Recommendation Report for Lawful Development Certificate for a Proposed Use or Development**REF NO:** K/22/15/CLP**LOCATION:** Broadbeach
39 Coastal Road
Kingston**PROPOSAL:** Application for a Lawful Development Certificate for proposed extensions to ground floor & alterations**DESCRIPTION OF APPLICATION**

Proposed Ground Floor Plan
(alterations and extensions)

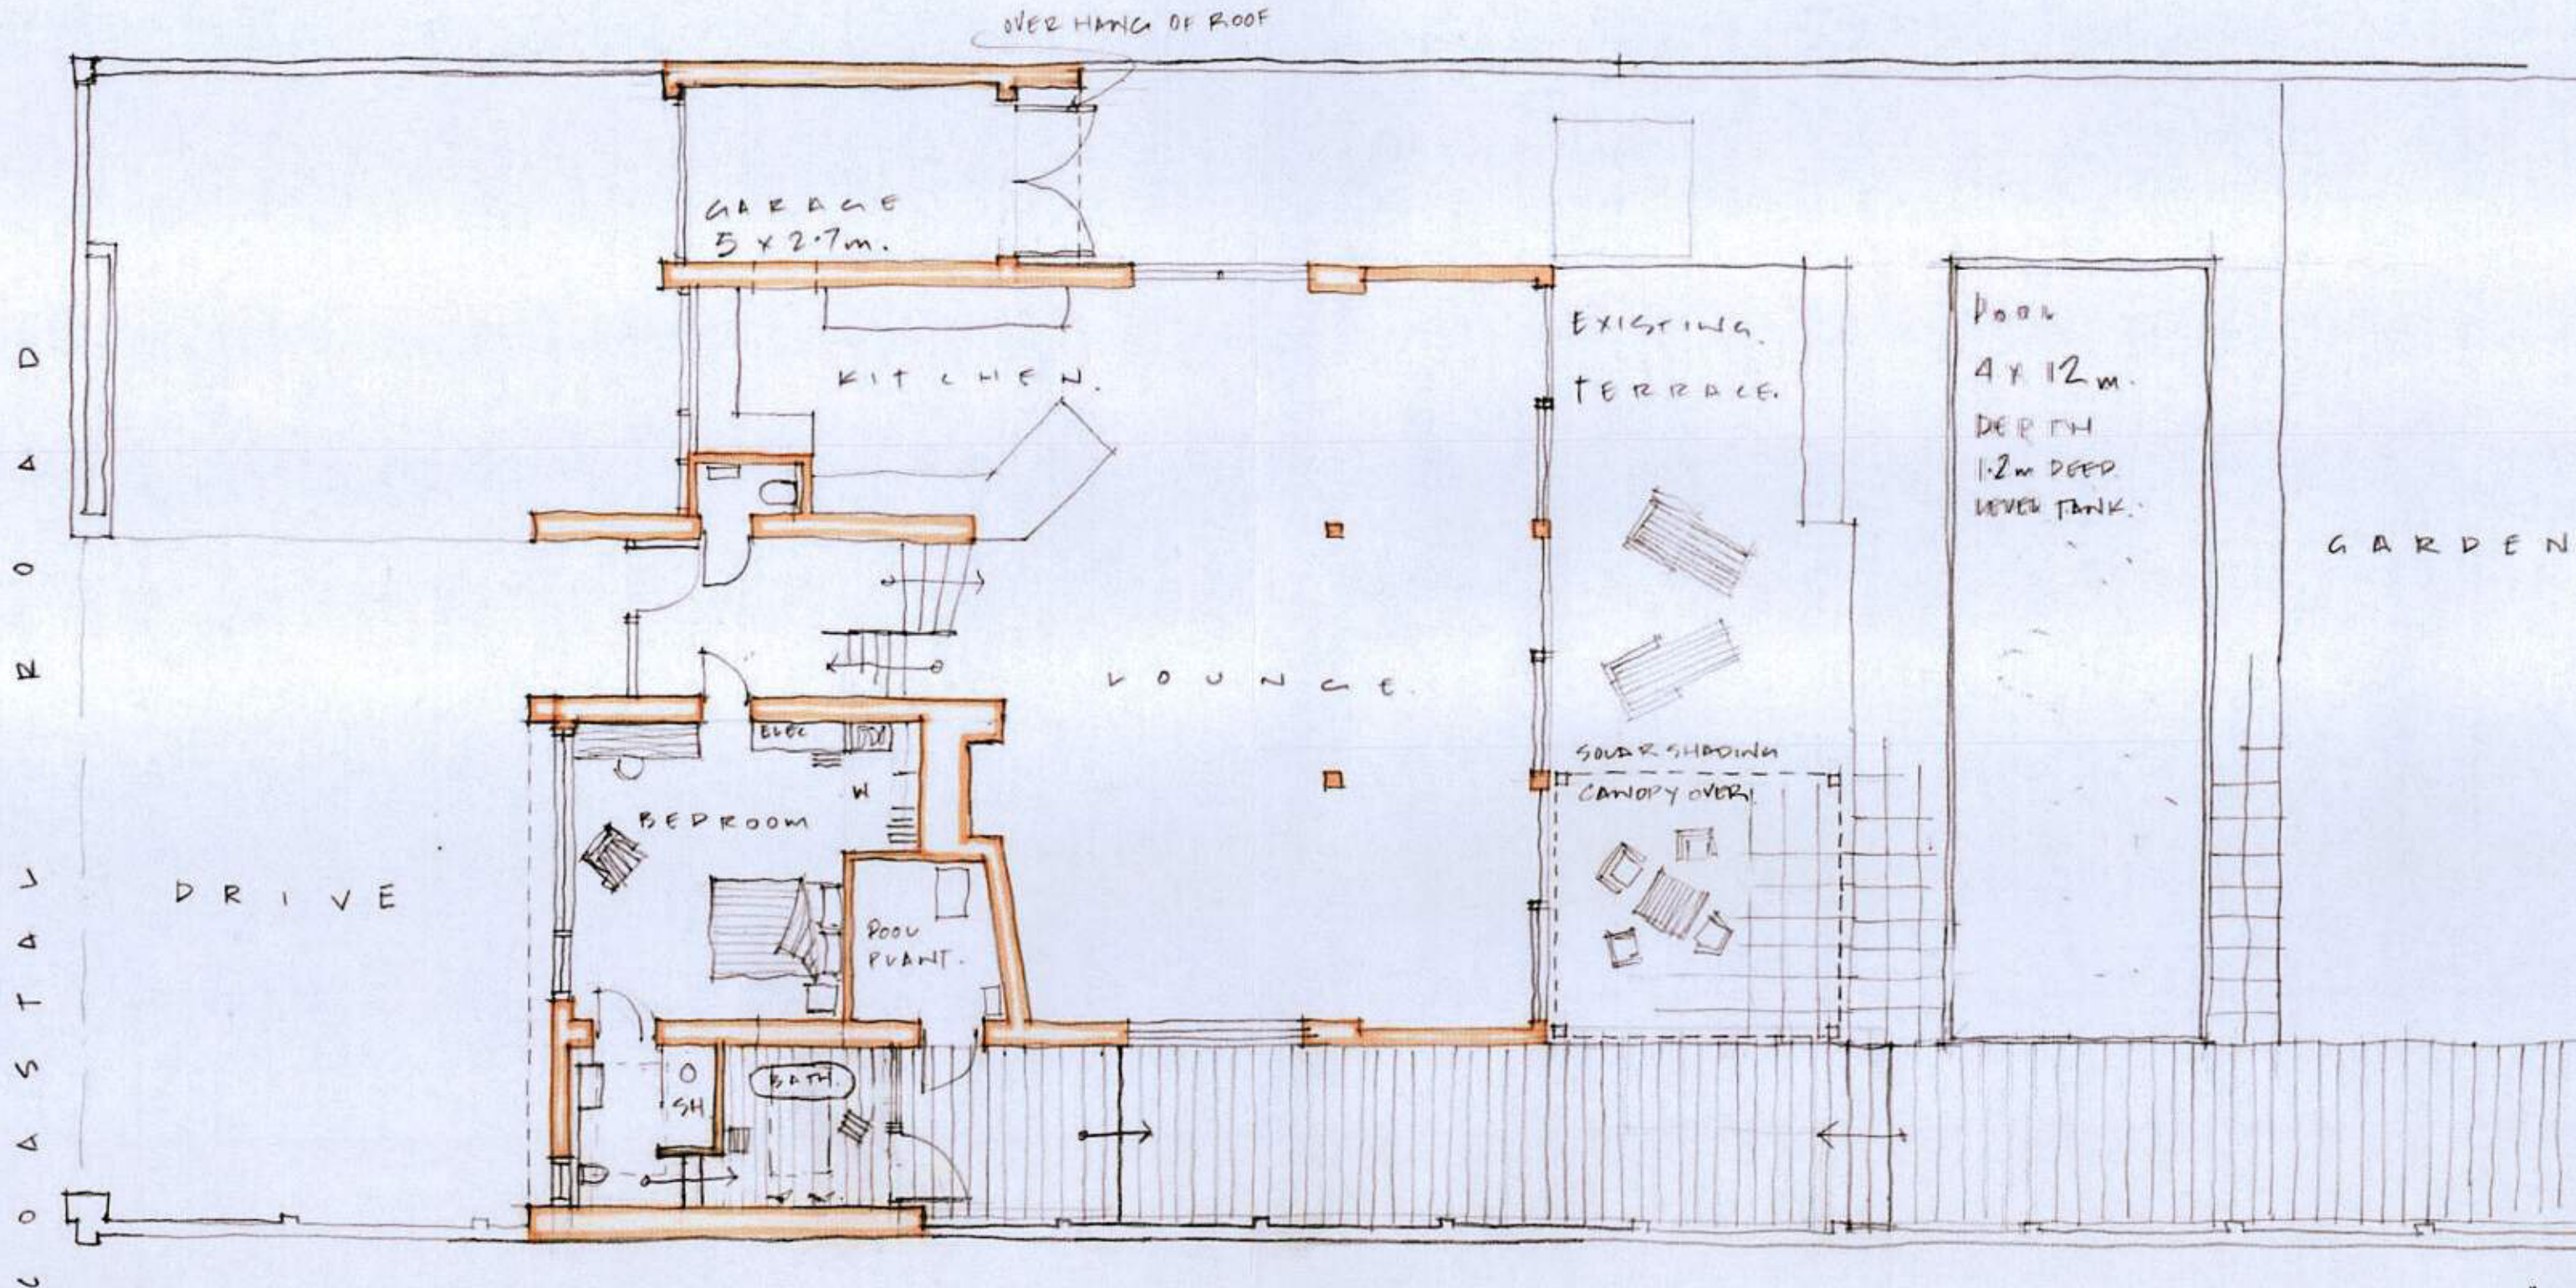
The existing flat roof above the porch, entrance hall and integral garage is part of the original property as constructed in the late 1960s. The applicants are proposing to replace part of this roof with a higher roof which extends to the side of the property as indicated.

4. The extensions do not extend beyond a wall which fronts a highway and which forms a principal elevation. The garage conversion element does not result in the development being closer to the highway and maintains the existing line of the front of the garage, substituting insulation and glazing materials for the garage door.

Proposed West & East Elevations  
(alterations and extensions)

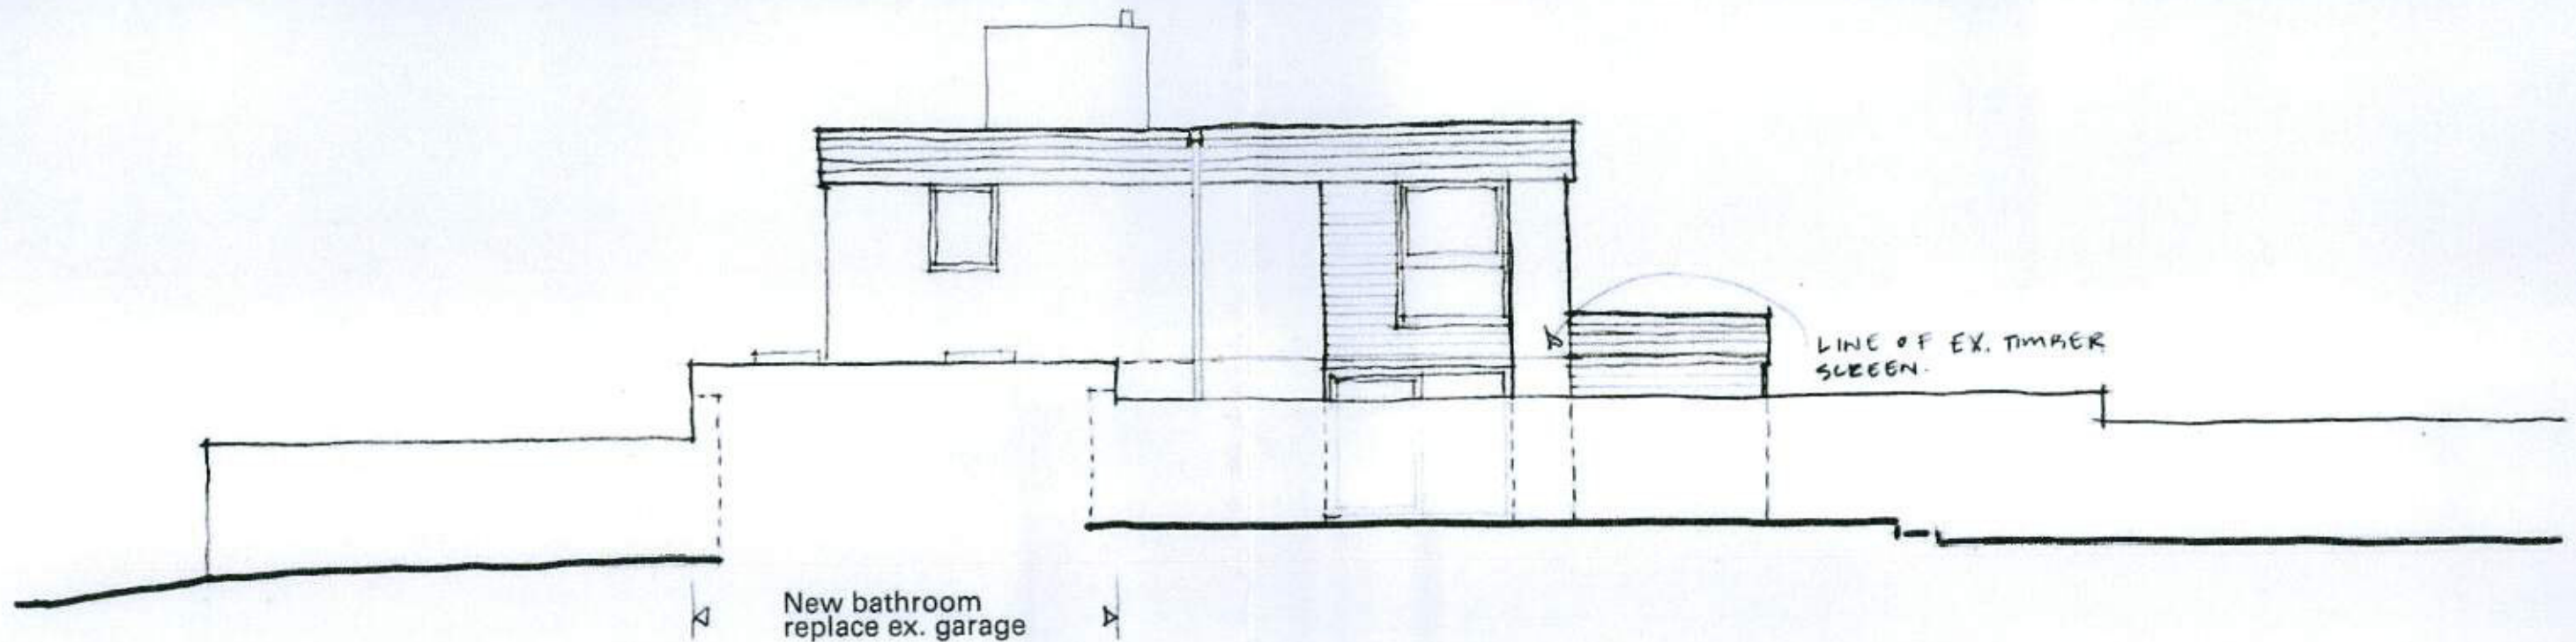
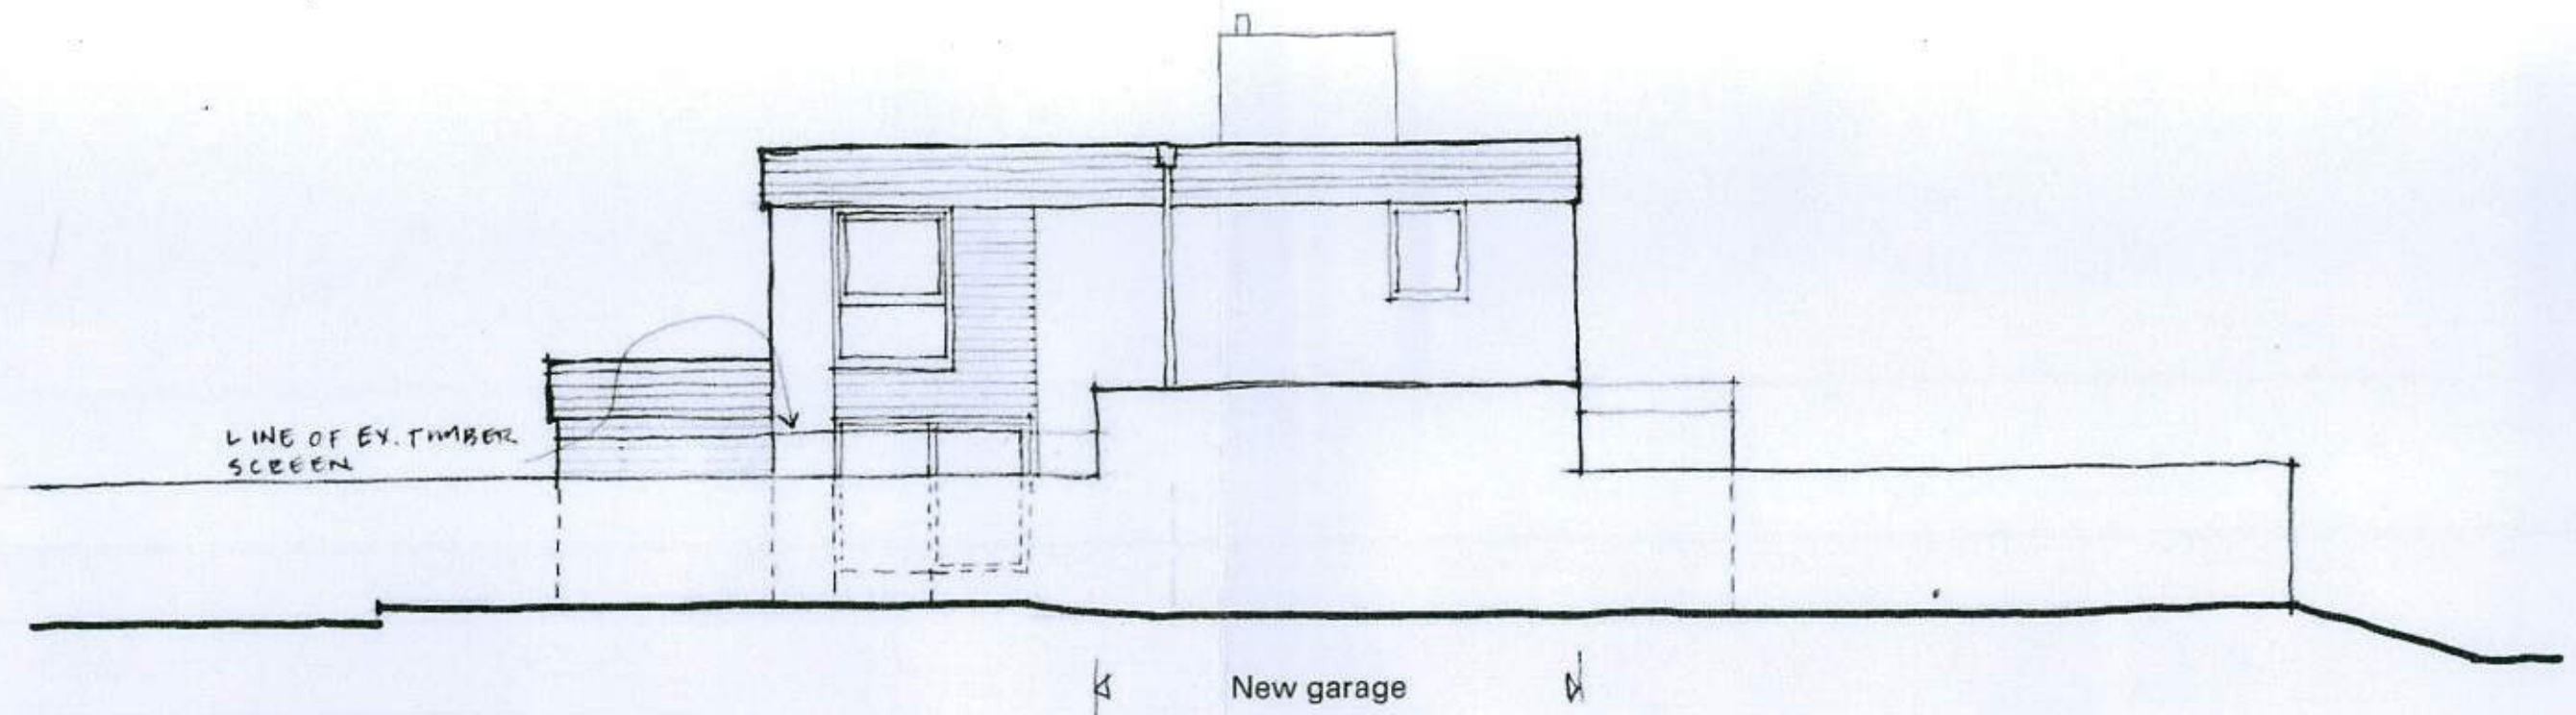
The flat roof at the front of the property is the smaller and lower of 2 flat roofs on the property and was part of the original property which was built in the late 1960s. This roof is approx. 2.6 metres in height and covers the porch, part of the interior entrance hall, and the front part of the integral garage including the garage door. The applicant proposes to raise the height of the part of this roof which is west of the porch to 3 metres as shown in the diagram of the "Proposed North Elevation". This clearly consists of an alteration to part of the roof, i.e. the application does not fall within the scope of Permitted Development.

The Planning Order 2015 relating to Permitted Development states that "Development is not permitted by Class A "if it would consist of or include an alteration to any part of the roof of the dwellinghouse" (Class A.1.(k)(iv)). Part of this roof is being raised in order to convert the integral garage into a bedroom which falls into the scope of Class A (the "enlargement, improvement or other alteration of a dwelling house"). It is therefore not Permitted Development.

This restriction applies to the main roof of the dwellinghouse. The specific word used is roof, not the plural roofs. The intention is to ensure that works that should be considered under Classes B or C cannot be carried out under Class A.

Class B covers additions or alterations to roofs which enlarge the house such as loft conversions involving dormer windows and not extensions of the type shown in this application.

8. The extensions are single storey.
9. The eaves do not exceed 3m in height within 2m of a boundary, measured from ground level within the site.
10. Does not consist of or include a veranda, balcony or raised platform. Does not involve a microwave antenna. does not include a chimney, flue or soil or vent pipe. And does not involve an alteration of the roof of the dwelling.

Proposed North & South Elevation
 (alterations and extensions)

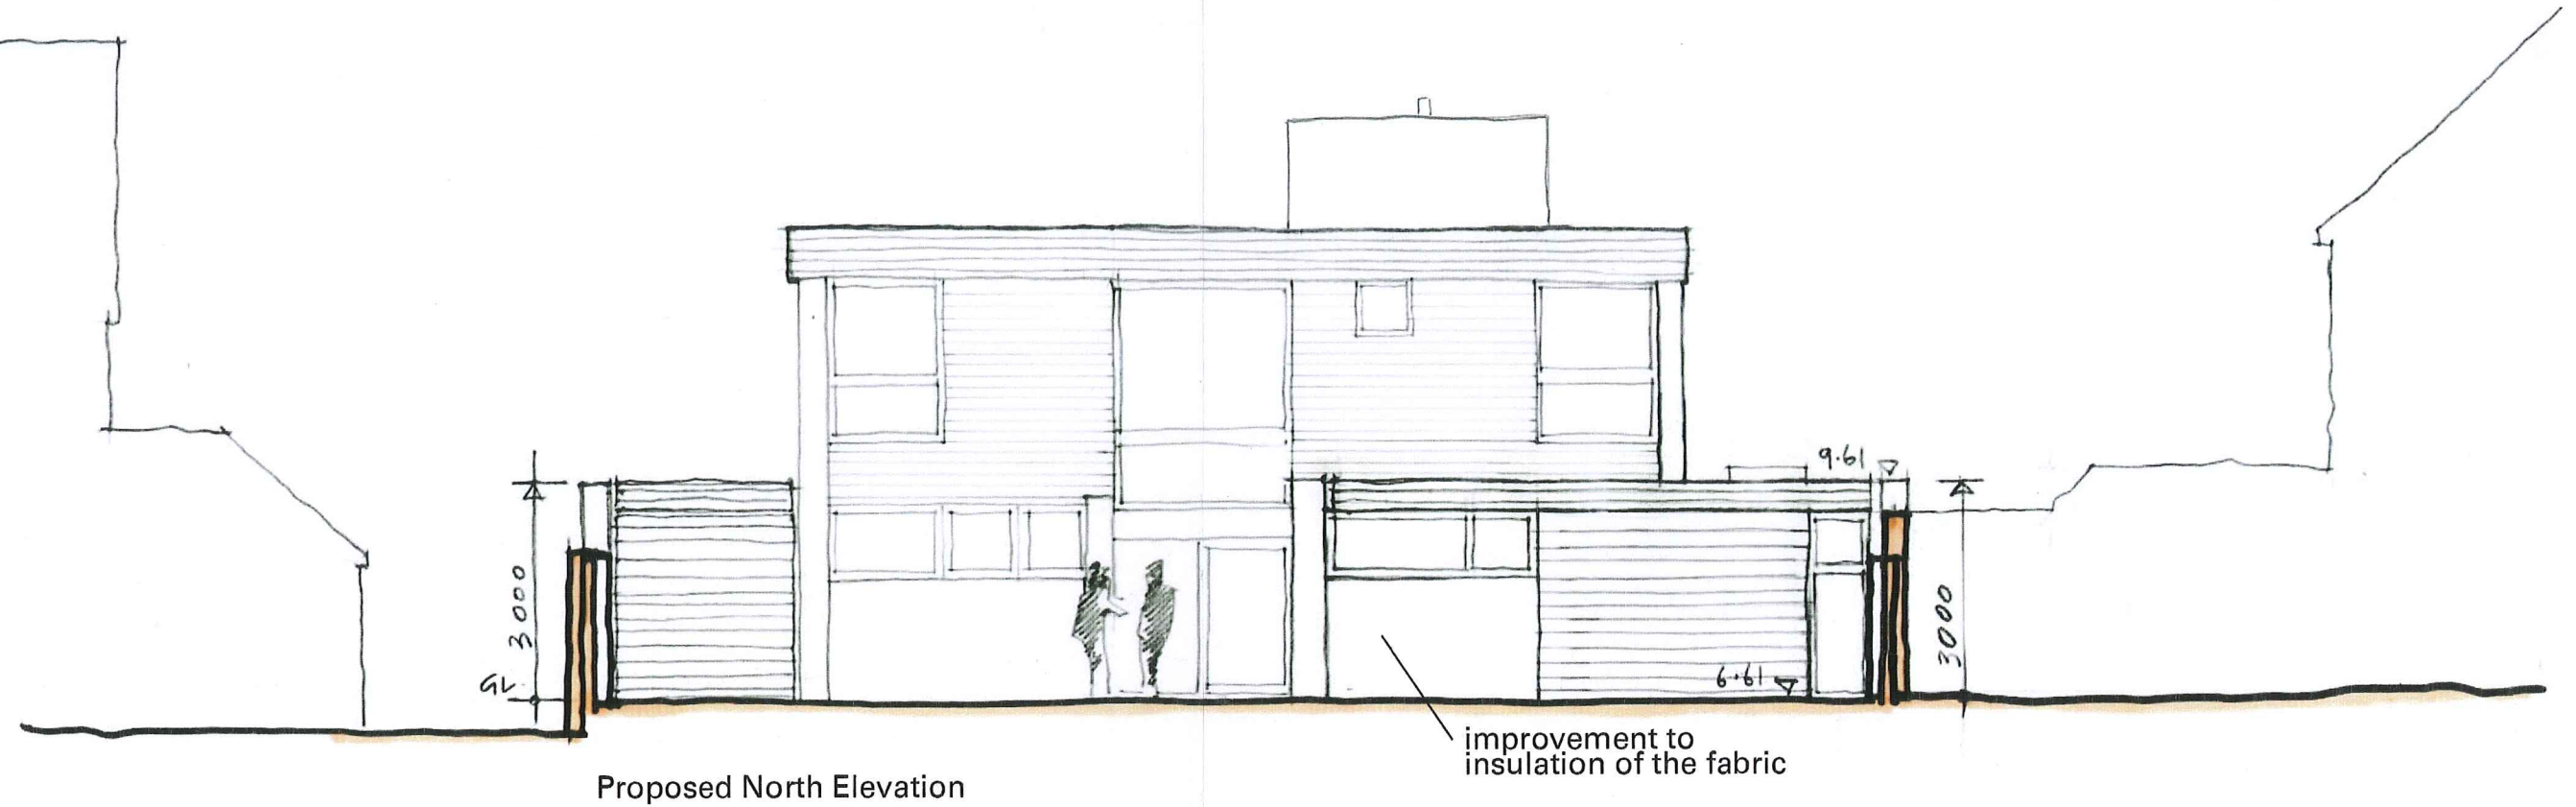
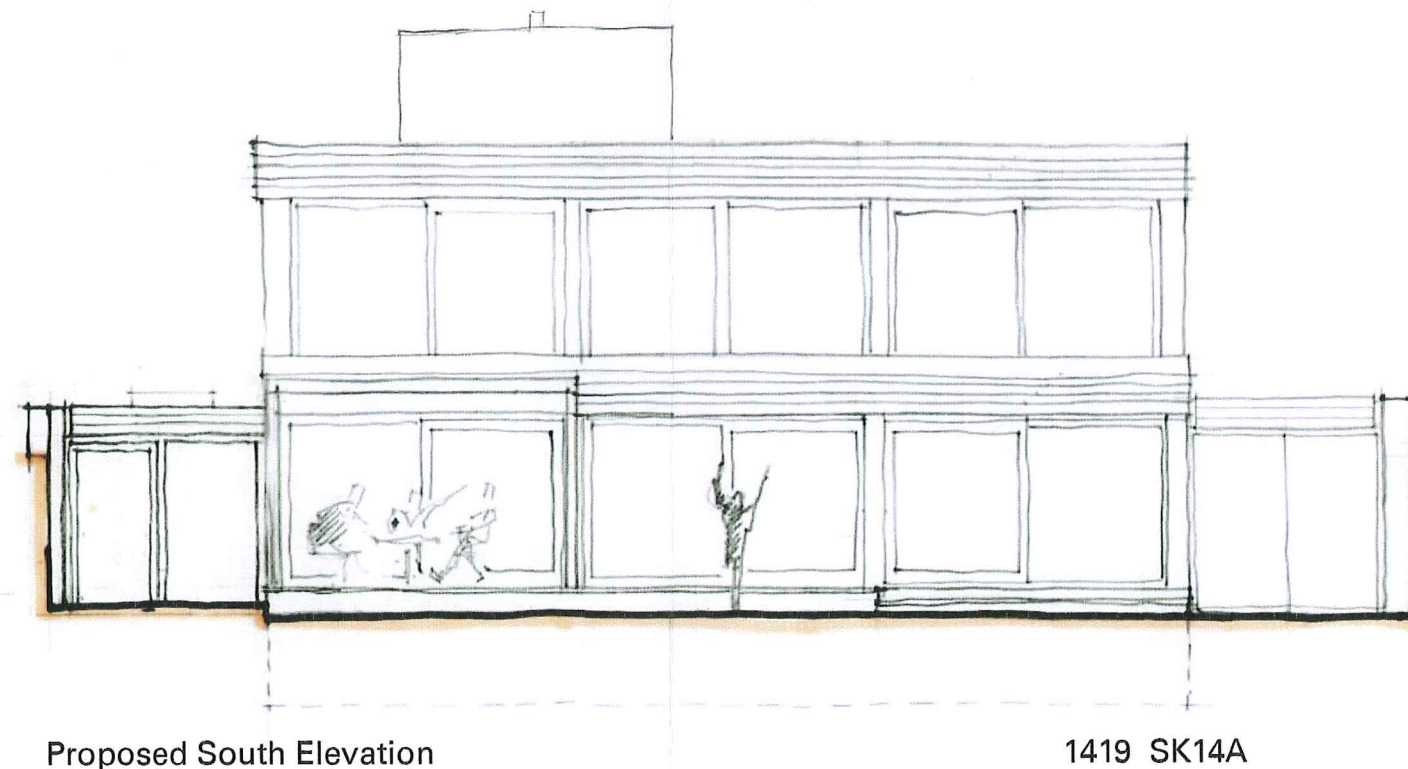
Finally, if the applicants were to argue that the roof of the property should be defined as the flat roof covering the top of most of the property and that the smaller, lower roof should be discounted, this would imply that the principal elevation of the property is the two storey wall which comprises the other part of the front of the property. If this were adjudged to be the case, the proposal would then be to extend beyond a wall which forms part of the principal elevation which is also not allowed as Permitted Development by Class A.1 (e)(i) of the 2015 Order.
